CITY OF ALBUQUERQUE

PLANNING DEPARTMENT – Development Review Services

November 19, 2015

RE: **Gutierrez Trucking Maintenance Facility**
3006 Todos Santos St. NW
Grading & Drainage Plan
Engineer's Stamp Date ~~8-26-2015~~ (File: G10D036)

GRADING & DRAINAGE PLAN
Scale 1"=20'-0"

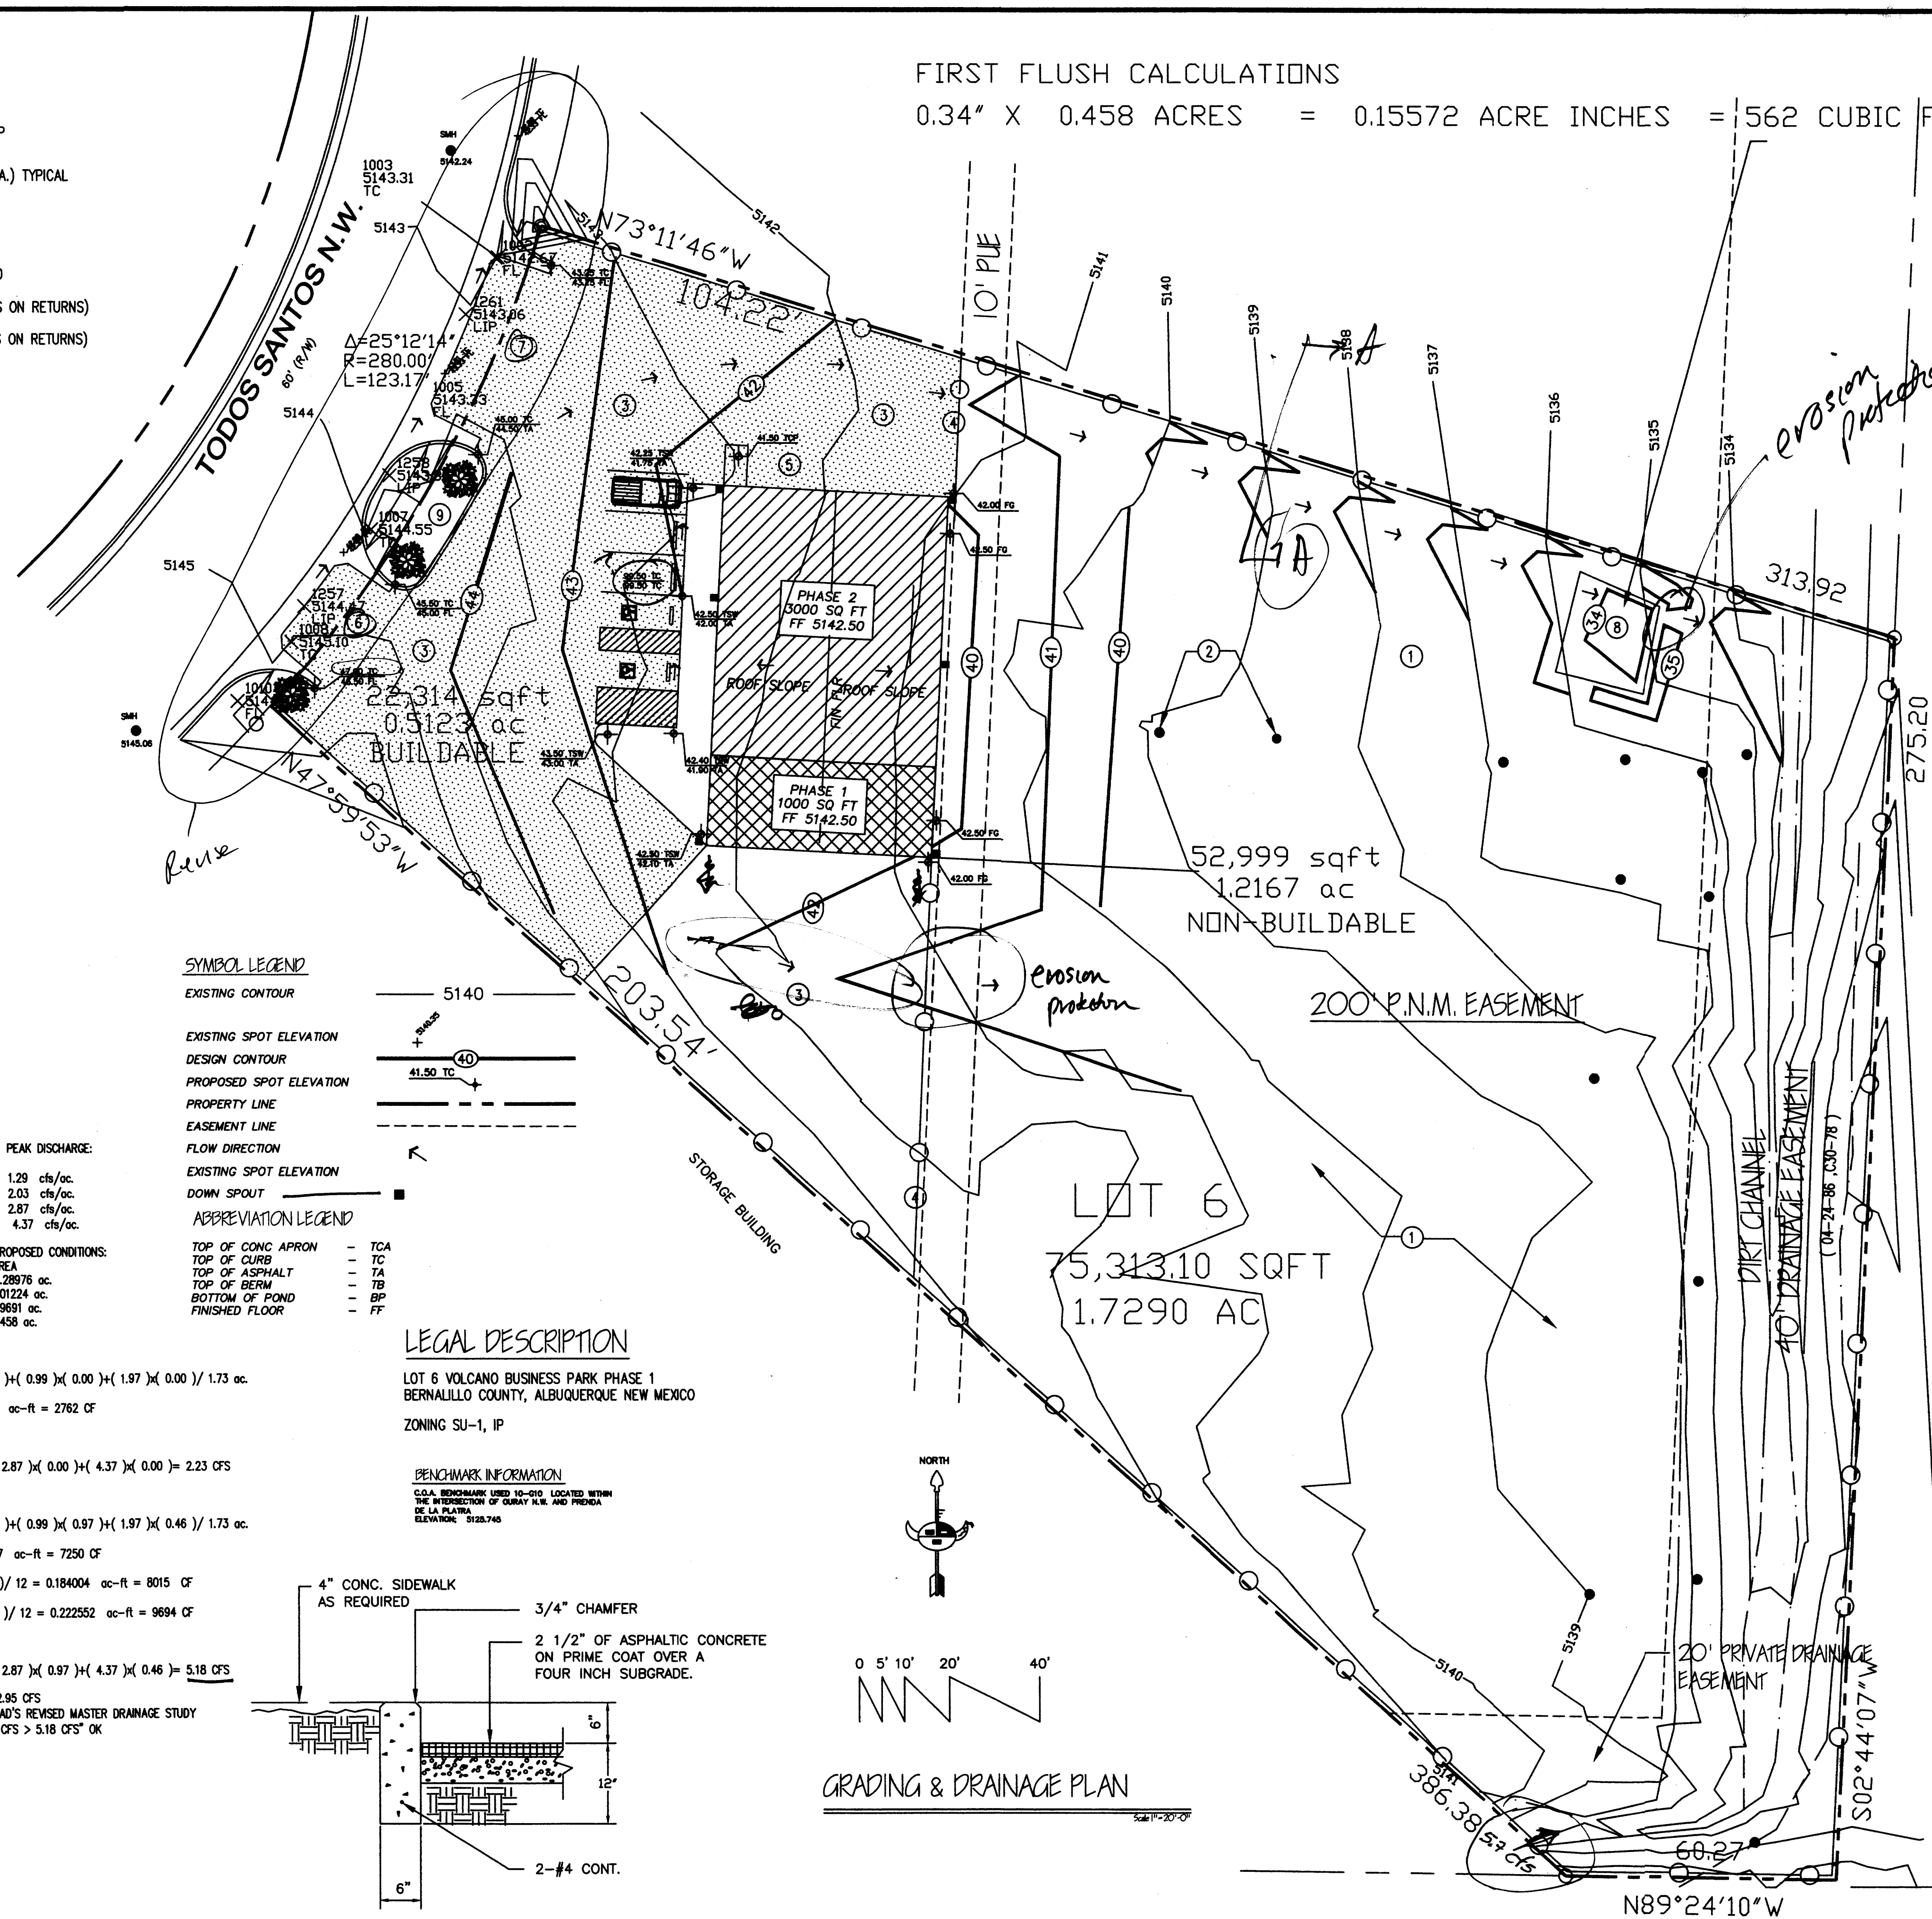
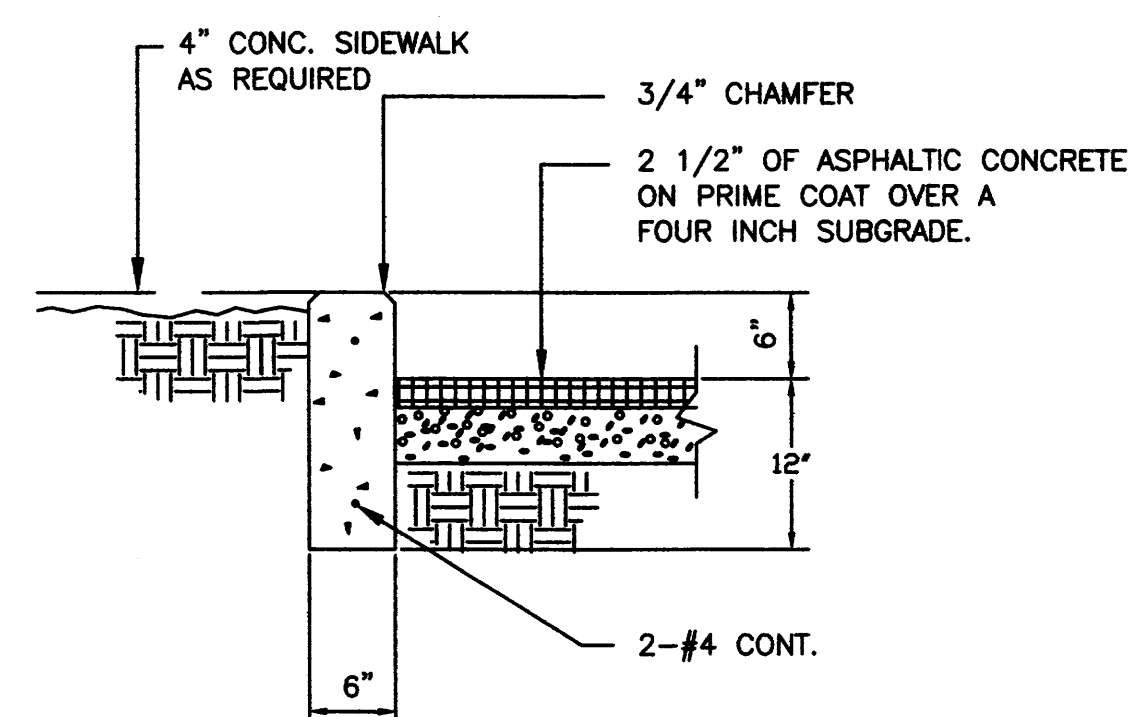
- 1) Narrative indicates this is a 2-phased project. Clearly show what is to be built in Phase I and what is to be built in Phase 2.
- 2) Regarding the 1st comment, show or state how drainage will be managed in Phase 1, before full build out and also for Phase 2 or full build-out.
- 3) Show with flow arrows the intended direction of the roof discharge.
- 4) Revise narrative regarding offsite flows. Drainage files G10D29D and G10D29F show that 5.7 cfs flow thru this site. Excerpt provided appears to have an error.
- 5) Per the City's MS4 Permit with EPA all sites must manage the "First Flush" onsite. Provide a first flush pond.
- 6) First flush can be calculated using $0.44'' - 0.10''$ (initial abstraction) = $0.34''$
- 7) Show Key notes 6 & 7 for the driveways on the plan

- 8) Flow line elevations in Todos Santos, and all curb return data.
- 9) Show water blocks and provide elevations
- 10) Show that all landscaping is depressed.
- 11) Since the disturbed area on this site exceeds 1.0 acre, an Erosion and Sediment Control (ESC) Plan, prepared by a NM PE and approved by the City's Stormwater Engineer, will be required for this site

- ✓ 1. Narrative indicates this is a two phased project. Clearly show what is to be built in phase 1 and what is to be built in phase 2. *Narrative has been revised to indicate what each phase will comprise of. Phase one will include everything except the 3000 sq. ft. metal building.*

- ✓ 2. Regarding the 1st comment, show or state how drainage will be managed in Phase 1, before full build out and also for Phase 2 or full build out. *The plan drawing has been revised to indicate how the two Phases will handle the drainage. Both buildings will have a gutter system which will drain the developed run-off towards the proposed swale.*

- ✓ 3. Show with flow arrows the intended direction of the roof drainage. *Plan drawing has been revised to indicate direction of roof drainage flow along with location of roof gutters.*

- ✓ 4. Revise narrative regarding offsite flows. Drainage files G10-D29D and G10-D29F show that 5.7 cfs flow thru this site. Excerpts provided appears to have an error. *Narrative has been revised to indicate the offsite flows entering the 40' drainage easement from lot 7A1.*

- ✓ 5. Per the City MS4 Permit with EPA all sites must manage the "First Flush" onsite. *Plan drawing has been revised to show the first flush calculations. A first flush pond has been included at the far end of the proposed swale just as enters onto the drainage easement.*

- ✓ 6. First flush can be calculated using $0.44'' - 0.10''$ (initial abstraction) $- 0.34''$. *Calculation has been included on the plan drawing.*
- ✓ 7. Show Key notes 6 & 7 for the driveway on the plan. *Key notes have been inserted next to the drive cuts on the plan drawing.*

- 8. Flow line elevations in Todos Santos, and all curb return data. *Flow line elevations and top of curb have been added to the plan drawing. Return data is part of the key notes.*

- 9. Show water blocks and provide elevations. *Plan drawing indicates the flowline elevation along with the water block elevation.*
- ✓ 10. Show that all landscaping is depressed. *Key not has been added.*
